Our Ref: LU/248/19/DOC

Approval of details reserved by condition imposed under ref APP/C3810/W/18/3197149 (LU/162/17/PL relating to Condition Nos 8 - materials & finishes, 9 - landscaping scheme, 10 - Construction Management Plan, 13 - visibility splays, 14 - pedestrian visibility plays, 16 - cycle parking and 18 - street lighting.

Land At Toddington Farm North And West Of 1 To 3 Toddington Toddington Lane Littlehampton BN17 7PN

Visibility Splay Site Plan - 1:200 @ A1

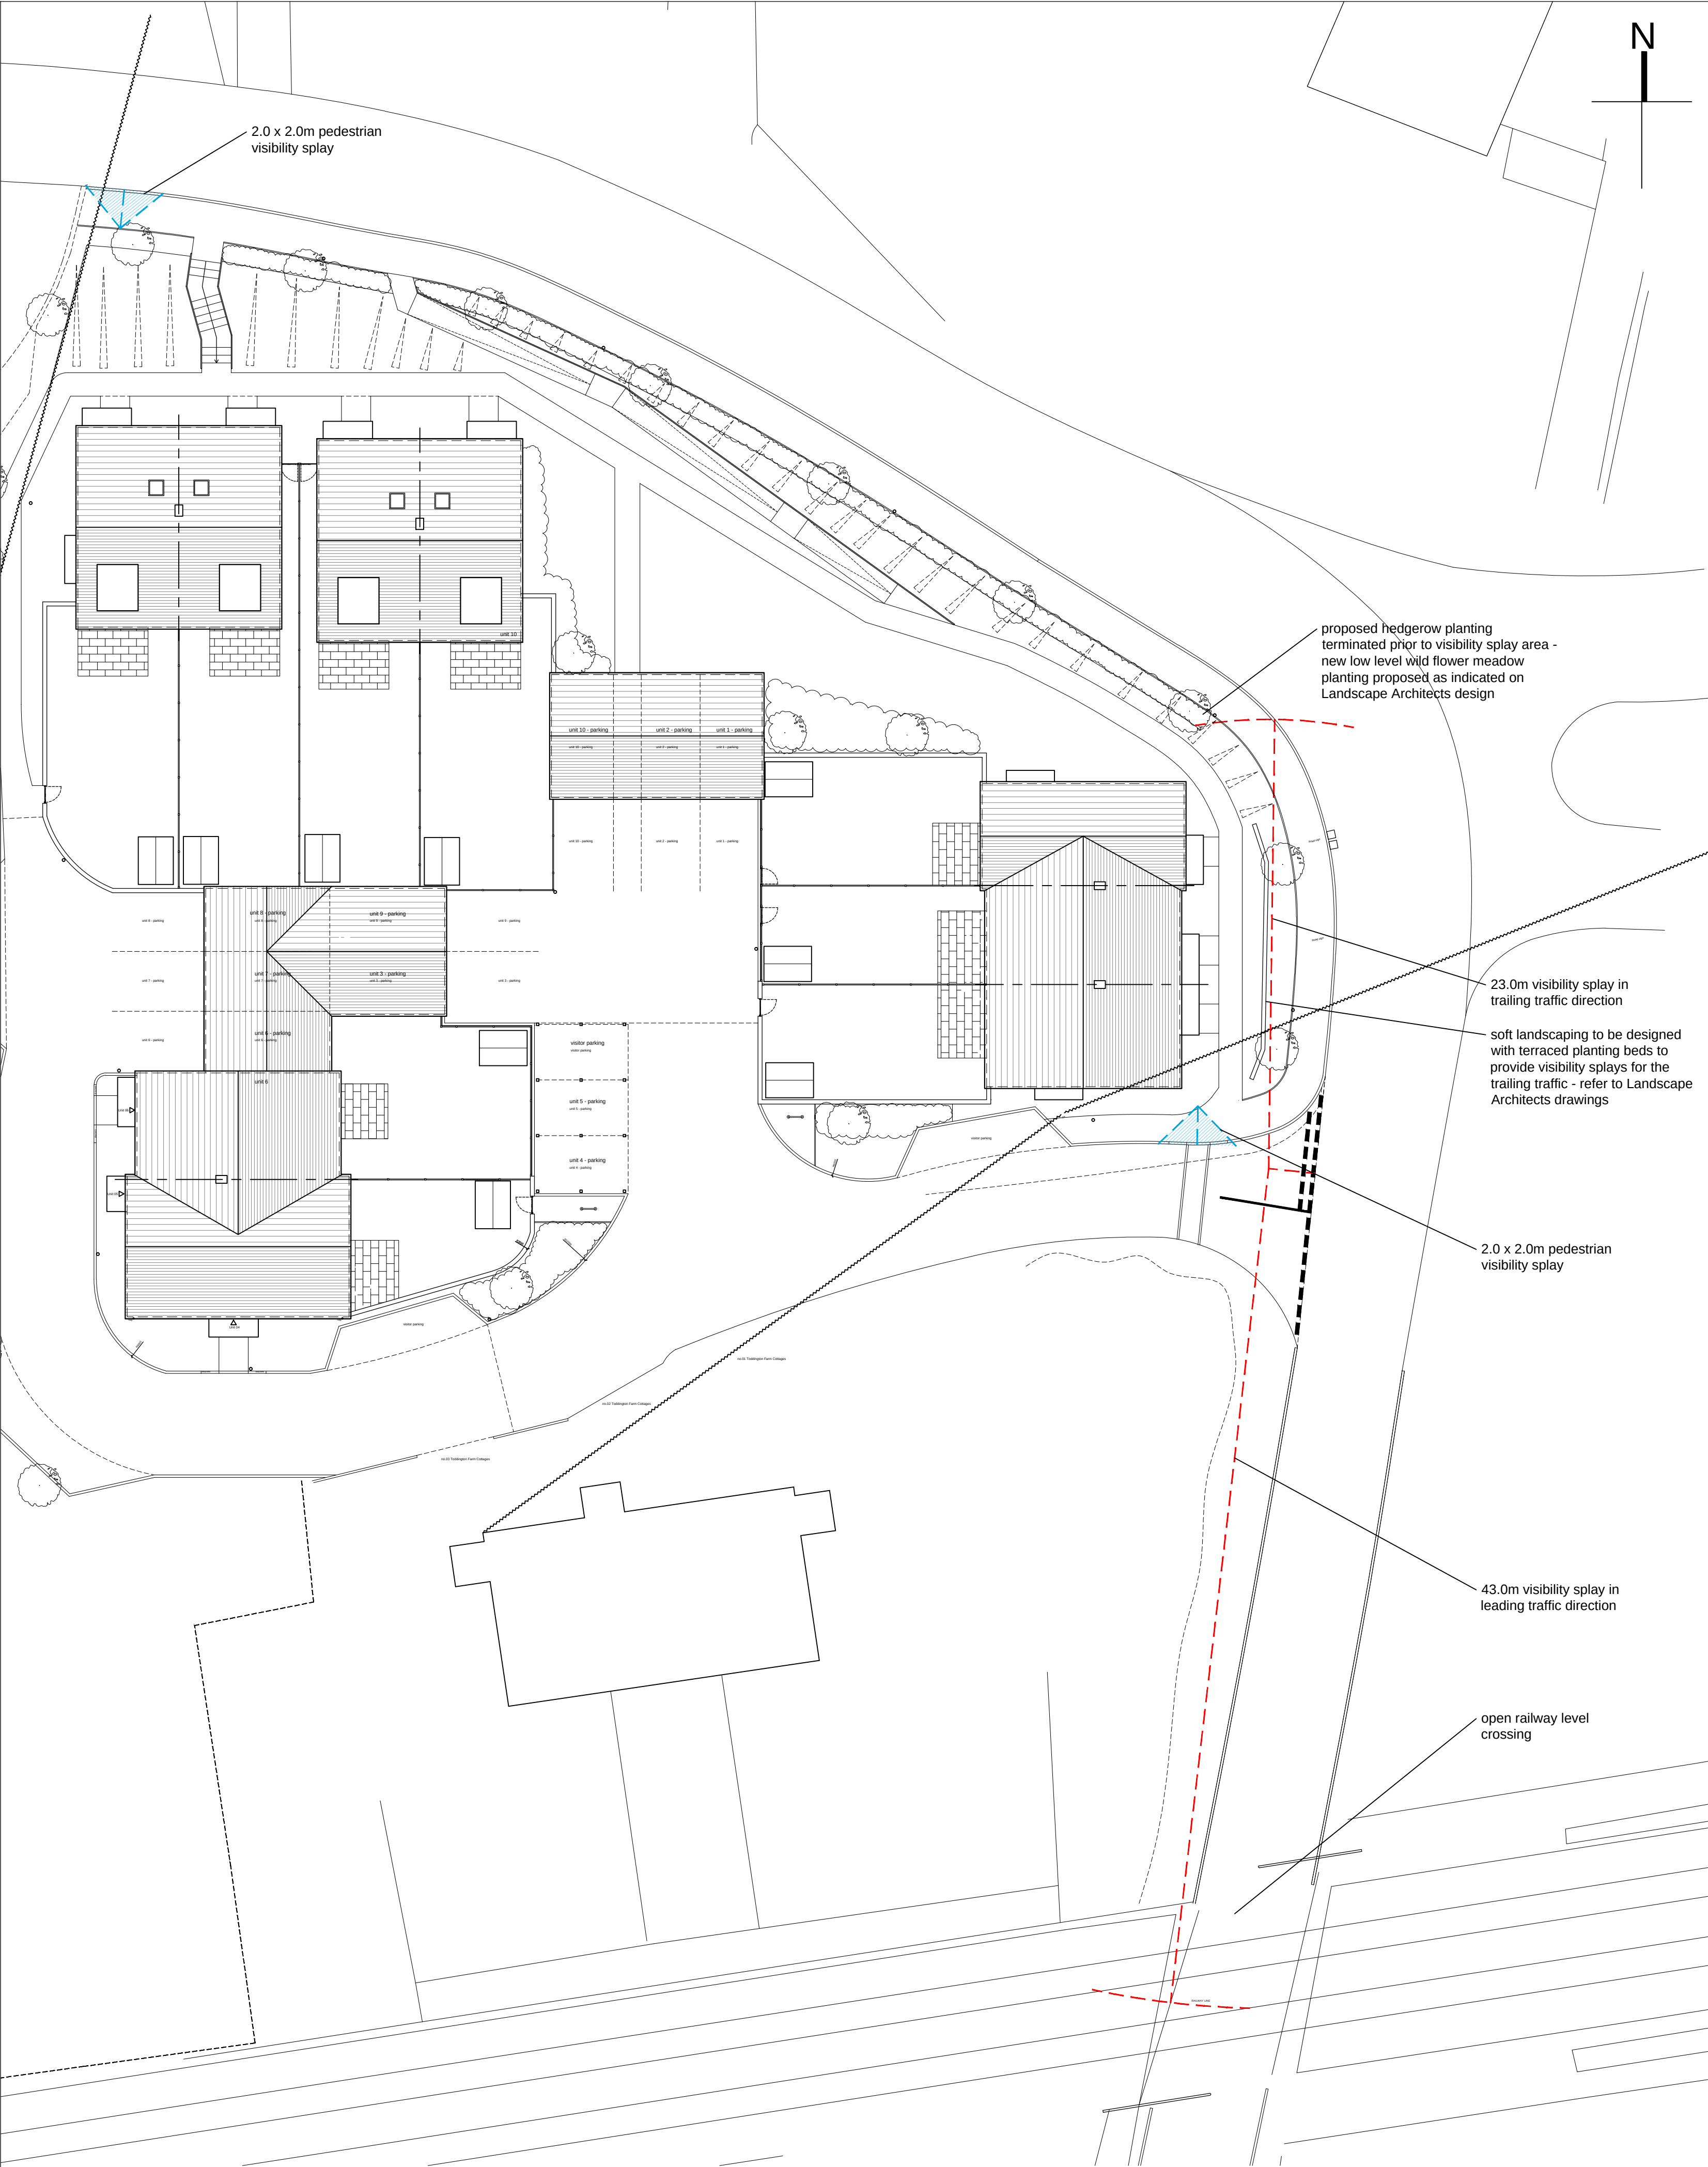
This condition is refused on the basis if the information submitted for the following reasons: The splay in the leading traffic direction (so looking south from the access point) appears acceptable. However, the one to the north (so trailing direction) only measures 23m. It is recommended that it be extended back into the site and then shown extending further northwards into the carriageway. Also, some form of structure appears to be shown in front of plots 1-3 which is on public highway. No structure would be permissible on highway land. Further additional details will be required in order for the condition to be discharged.
